**Application by The Drovers Solar Farm Limited for an order granting Development Consent for The Drovers Solar Project**

**Planning Inspectorate Reference Number: EN0110013**

**Comments on Applicant's Response to National Highways' Relevant Representations submitted on behalf of National Highways**

**Figure 3-2: A47 Temporary Works for AIL Movement**

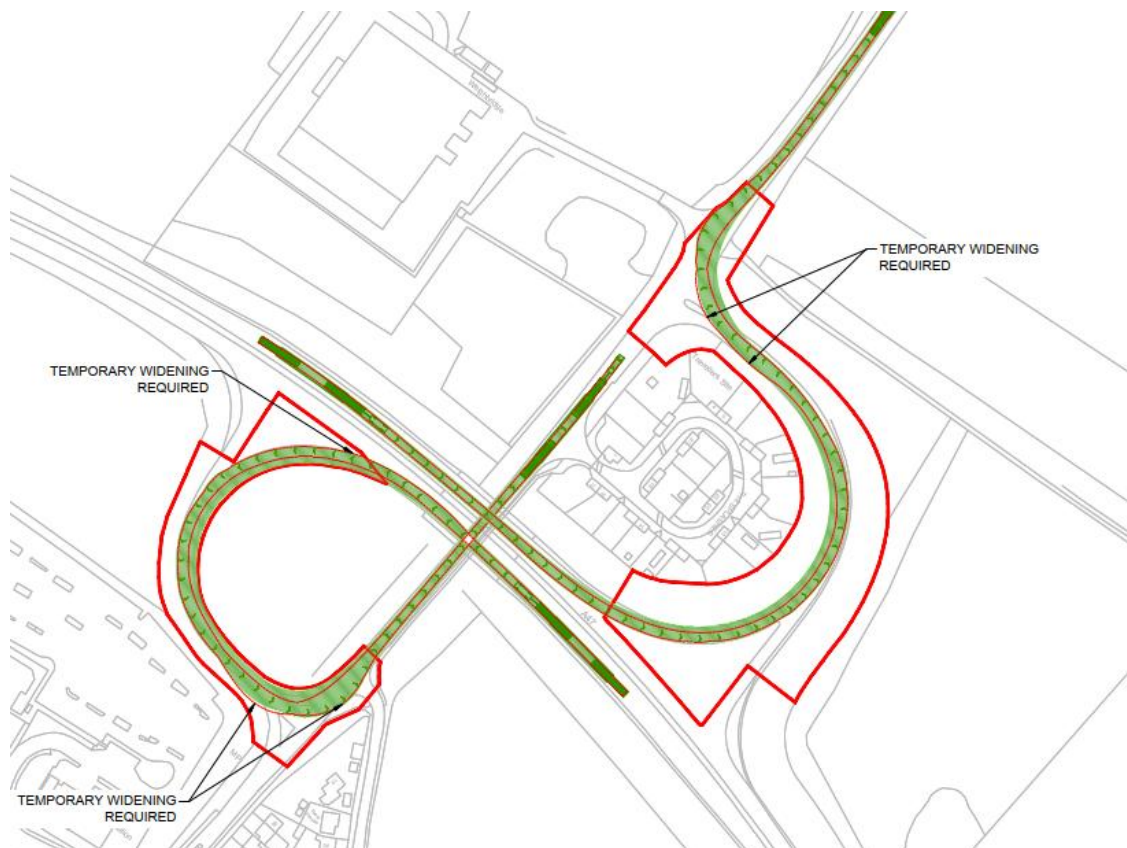
<p>The works are temporary highway works at the A47 / A1065 junction which may include verge reinforcement, temporary street furniture removal, vegetation removal or temporary widening that may be required for the future AIL delivery at the junctions, as set out within the oCTMP [APP/7.7.1] and ES Appendix 9.2: Traffic Assessment [APP-163]. The works would be temporary in nature and only for the AIL delivery, being reinstated to the original condition post delivery of the AIL. The works, including any technical approval protocols, Road Safety Audits and traffic management, are secured through the oCTMP [APP/7.7.1] and will be confirmed to National Highways via the contractor as part of the AIL license protocol and via the detailed Construction Traffic Management Plan provided prior to commencement of construction.</p>	
<p>NH9</p>	<p><b>Plot: 5-47</b>  <b>Owner: NH</b>  <b>Acquisition Category: Temporary Possession</b>  <b>Works Proposed (Taken from the Applicant's statement of reasons): Purpose One</b></p> <p>NH Comments:  The Book of Reference notes that NH are a Category 2 person in respect of rights granted by a Deed of Exchange dated 17 December 1984.  NH require further details of the works proposed on this parcel. If there are any potential traffic management implications, then NH require to be consulted before works take place. The Applicant should be required to obtain NH's consent in the event the activities affect the SRN or any land NH has an interest in. As a public body, NH is under a duty to act reasonably in providing such consent and this is expressly provided in paragraph 7(4) of NH's proposed protective provisions at Appendix 1.</p>	<p>In respect of the request for the Applicant to seek National Highways' consent, the Applicant notes that this is included in the form of protective provisions for the benefit of National Highways referred to in other rows of this response, including above in relation to NH2.</p> <p>The works are temporary highway works at the A47/A1065 junction which may include verge reinforcement, temporary street furniture removal or temporary widening that may be required for the future AIL delivery at the junctions, as set out within the oCTMP [APP/7.7.1] and ES Appendix 9.2: Traffic Assessment [APP-163]. The works would be temporary in nature and only for the AIL delivery, being reinstated to the original condition post-delivery of the AIL. The works, including any technical approval protocols, Road Safety Audits and traffic management, are secured through the oCTMP [APP/7.7.1] and will be confirmed to National Highways via the contractor as part of the AIL license protocol and via the detailed Construction Traffic Management Plan provided prior to commencement of construction.</p>	<p>NH acknowledges the points made by the Applicant. NH is in ongoing discussion with the Applicant regarding an acceptable form of Protective Provisions.</p> <p>NH notes that the CTMP has been updated and will review this.</p>
